Our ref: Trinity Grammar School Redevelopment-Mod-1 (SSD-10371-Mod-1)

Subject: Response to Submissions

Key Issues

Figure 1

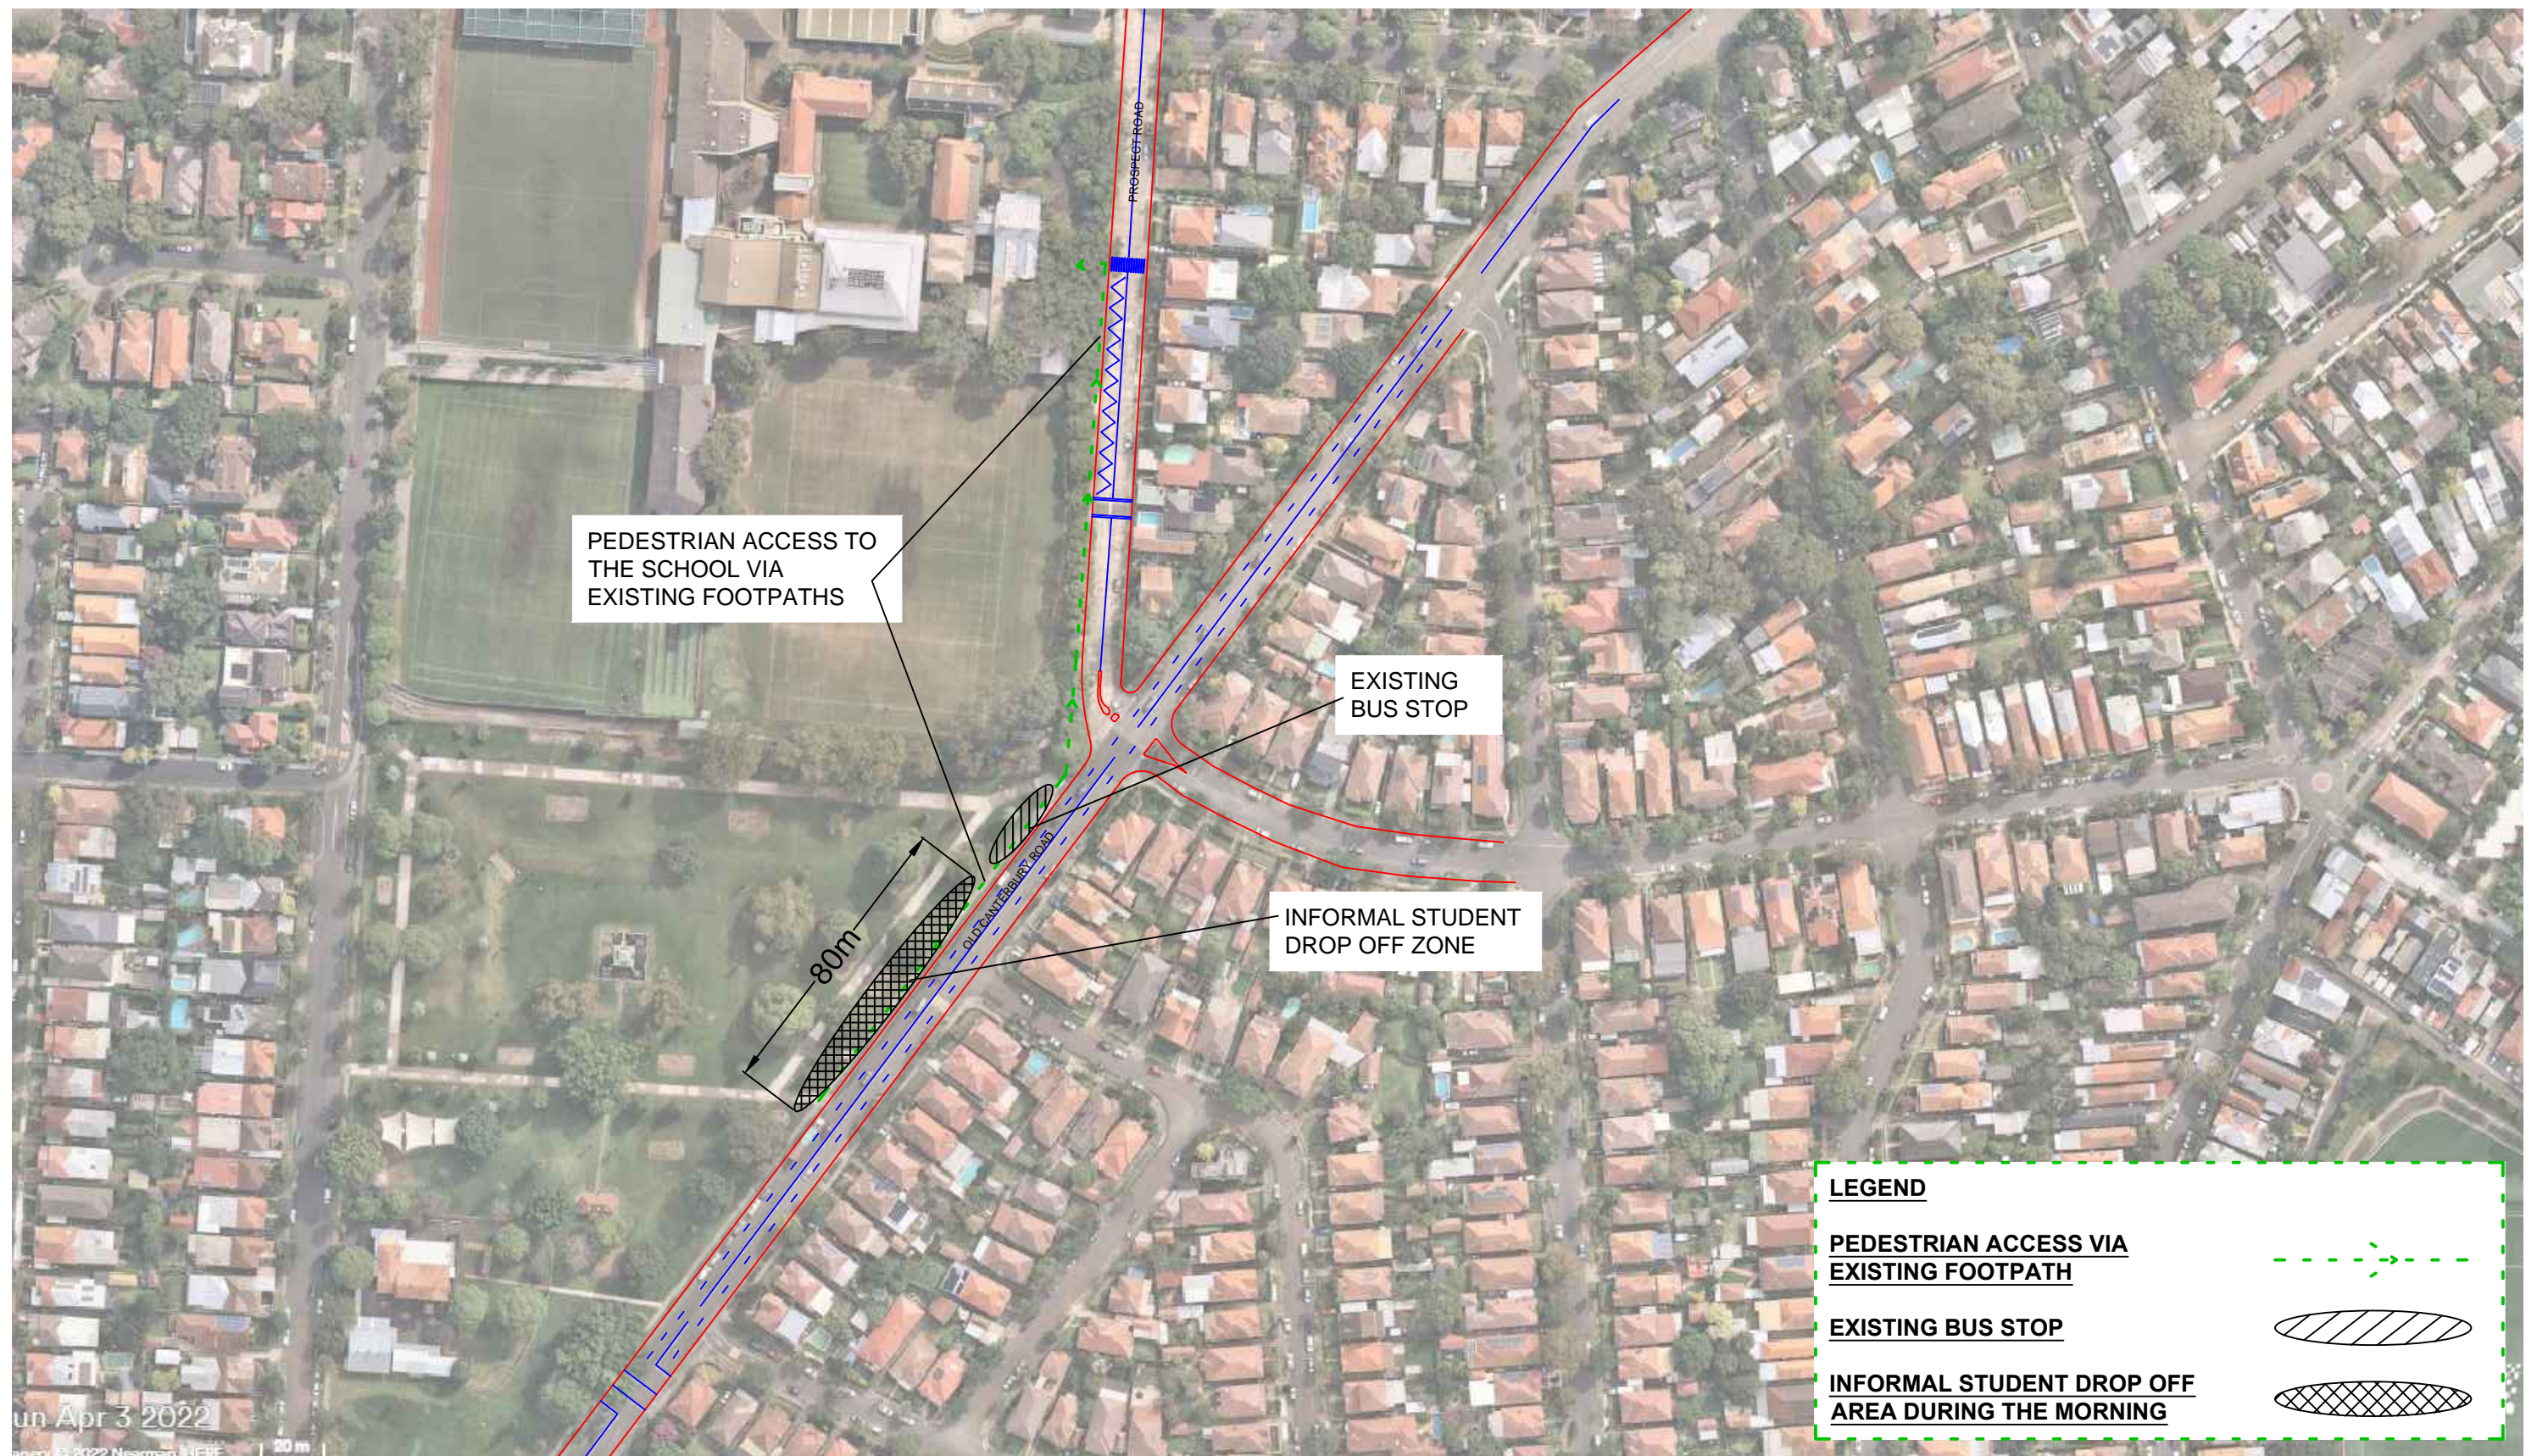
- (a) You are requested to identify the temporary drop-off/pick-up (DOPU) zone on Old Canterbury Road in a scaled site plan along with identification of existing driveway crossings, existing street signs including bus zones and no stopping zones. You are also requested to include information on the length of the DOPU zone and the number of cars that can be accommodated in this zone during peak time.
- (b) You are requested to demonstrate how students would safely access the school site from the temporary DOPU zone on Old Canterbury Road.
